Memorandum of Advice

Traffic Generation from Proposed Gunnedah Recycling & Resource Recovery Facility

The following responses to Department of Planning and Environment request for further information have been provided by StreetWise Road safety & Traffic Services.

DRAWING TITLE				
SWEEP PATH ANALYSIS PLAN - B DOUBLE				
PROJECT NO.	PLANSET NO.	RELEASE NO.	DRAWING NO.	REVISION
P1907434	PS01	R16	PS01-GZ10	L

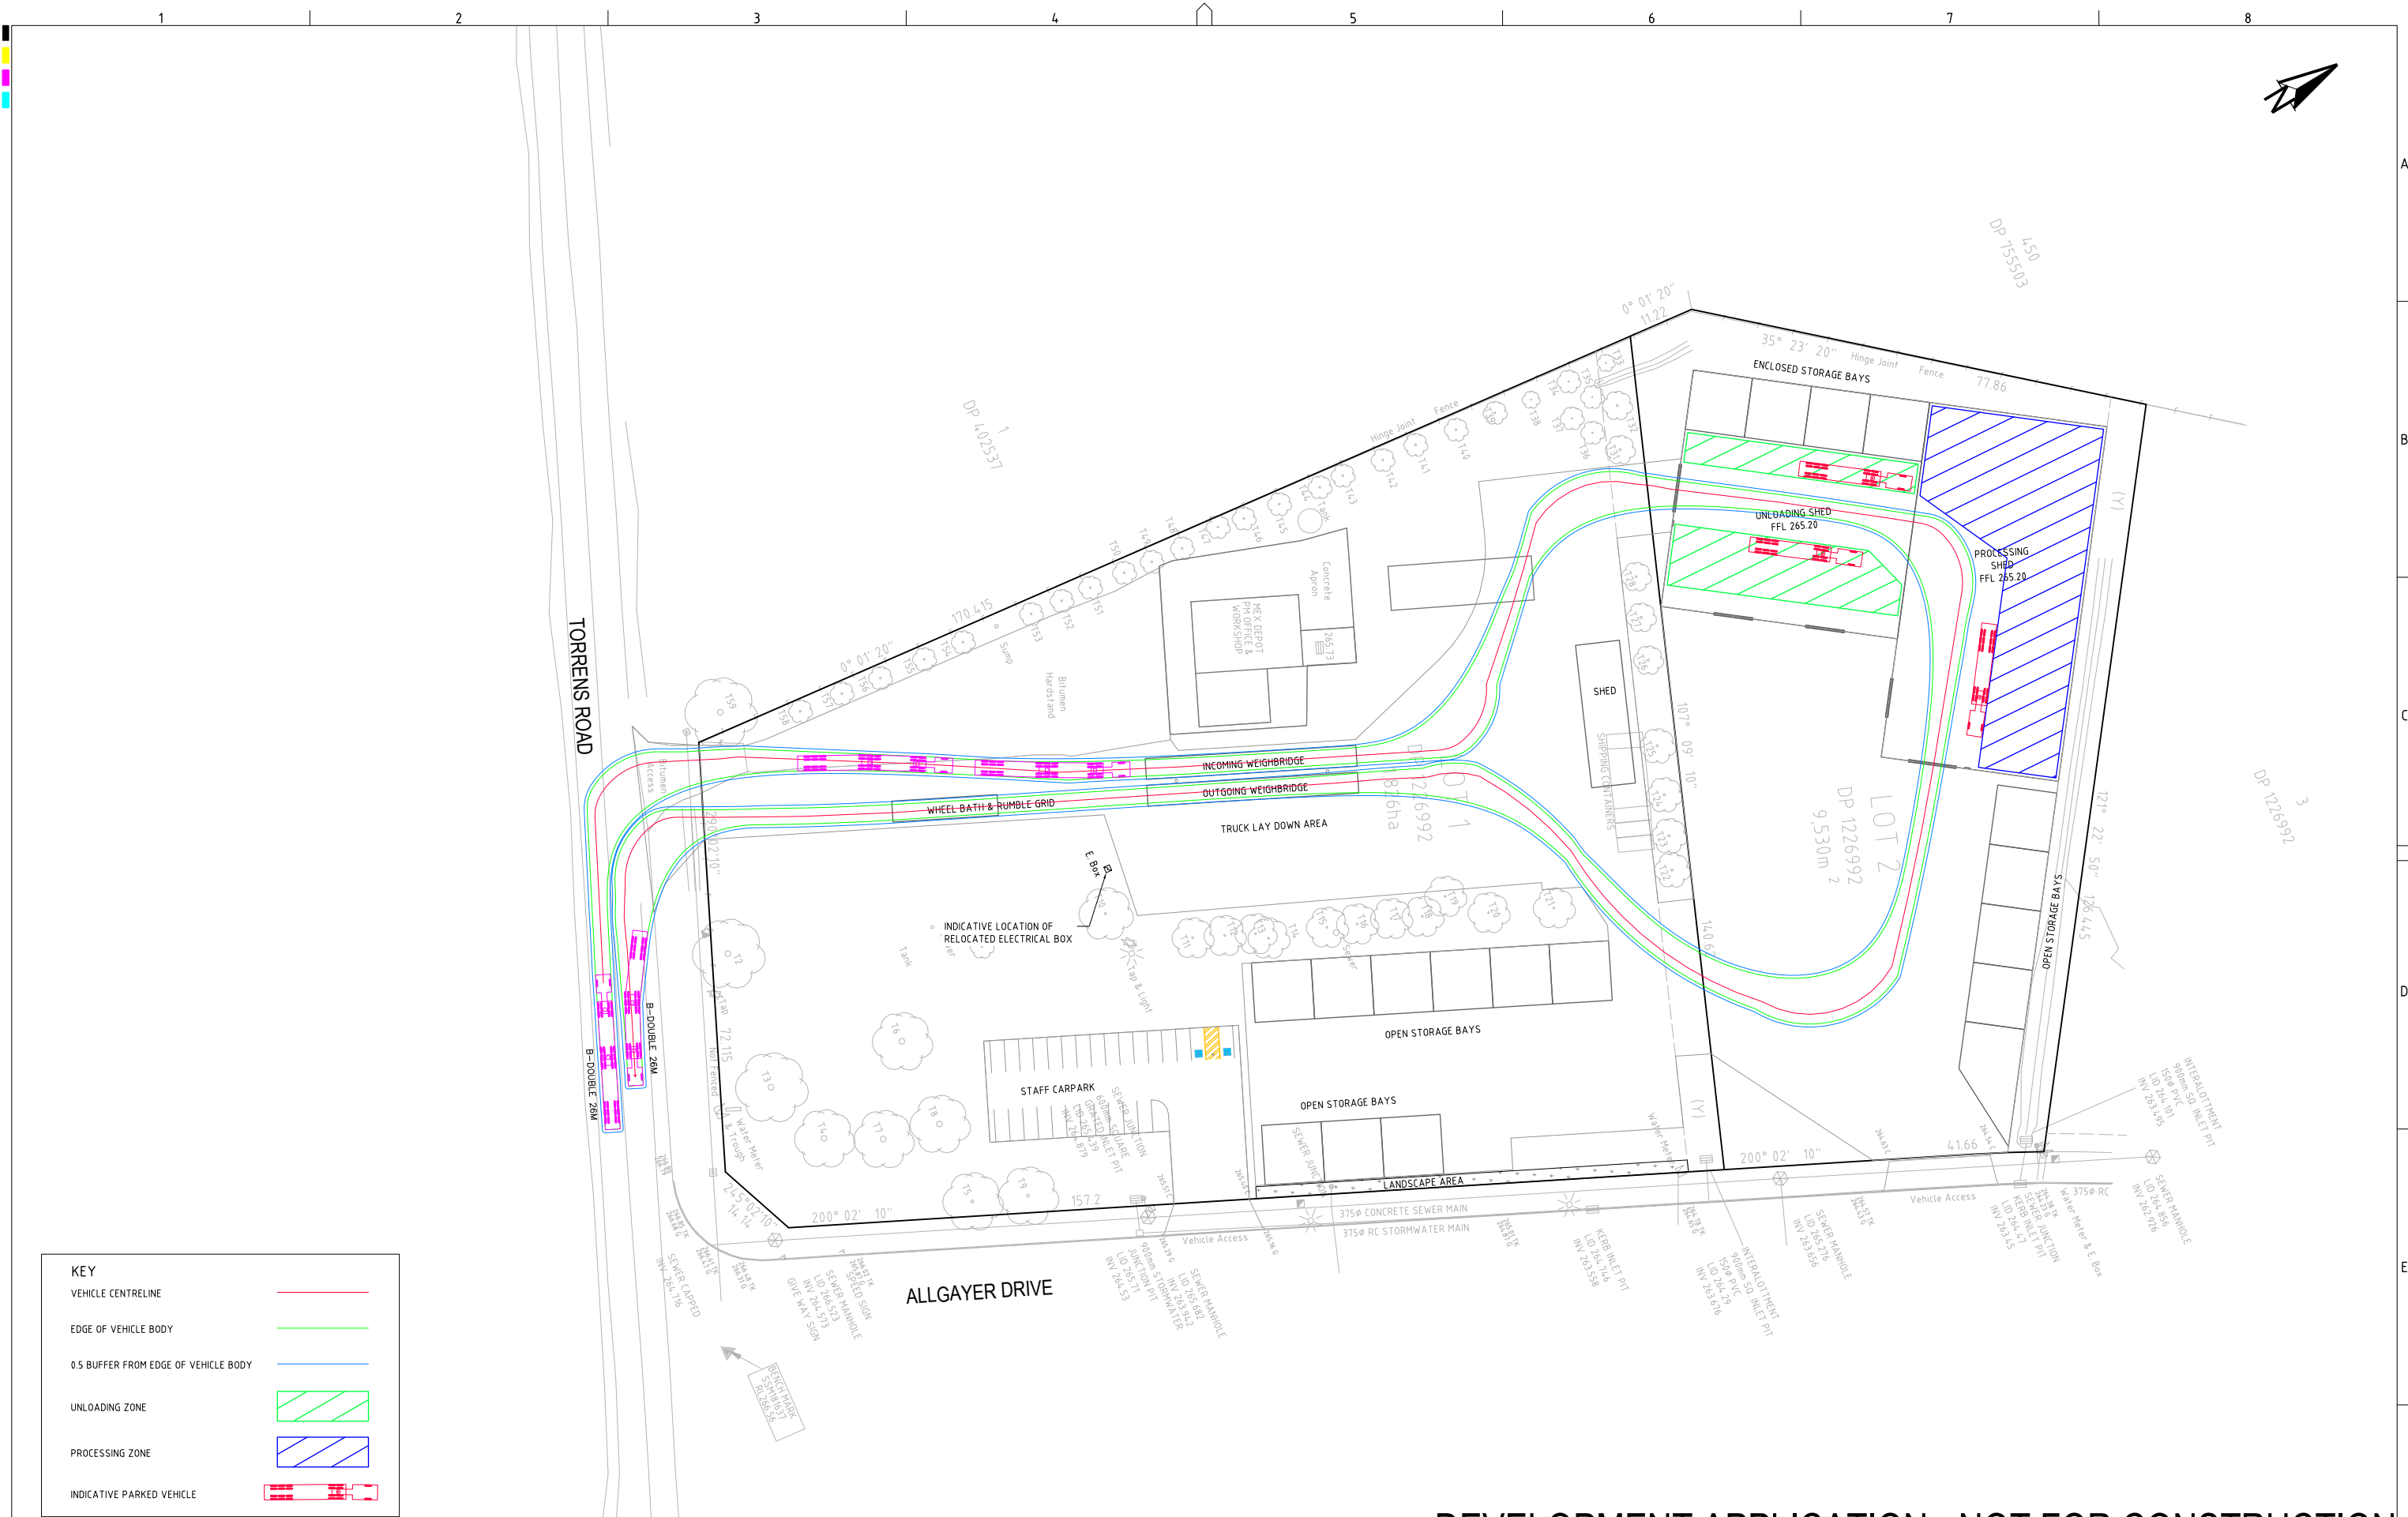
"Confirm the largest vehicle expected to enter the site and provide swept paths for this vehicle. Please provide swept path diagrams showing vehicles exiting the site onto Torrens Road."

"Describe how site traffic will be managed when a B double or B triple (as shown in swept path diagrams) is turning right to enter the site as other vehicles would not be able to exit simultaneously based on the current width of the driveway."

The design plans for the future Recycling & Resource Recovery Facility have been updated. The amended plans show details of the upgraded driveway / access from Torrens Road into the site, as well as turnpaths for B-double vehicles. As can be seen from the image below, and the swept-paths provided by Martens & Associates, the widened driveway provides adequate width for all heavy vehicles to turn safely in and out of the site, without the need to cross the Torrens Road centreline.

See swept turnpath by Martens & Associates above. Also, when the Waste Facility is approved and completed, the operators will prepare a Traffic Management Plan, Vehicle Movement Plan and Driver's Code of Conduct for the site and related activities. This will show the safe access in & out of the site, as well as required movements within the site. The traffic plans & documents will provide directions for safe movements, parking and activities for all drivers, and is likely to include signage, linemarking, scheduling of all heavy vehicle movements and instructions for 2-way radio operations.

"Provide an assessment of stacking spaces available and how the site will avoid vehicles queuing in the public road network."

The swept turnpath diagrams indicate the future site will cater for up to 3 B-doubles entering the site at the same time, with 1 on the weighbridge and 2 queued within the entry road. At the same time, there will be adequate width to allow heavy vehicles to exit via the same driveway without conflict.

Also, it is proposed that a Vehicle Movement Plan will be prepared to manage vehicle movements on the site when the facility is operational, including drivers being in radio communication with the site and other drivers.
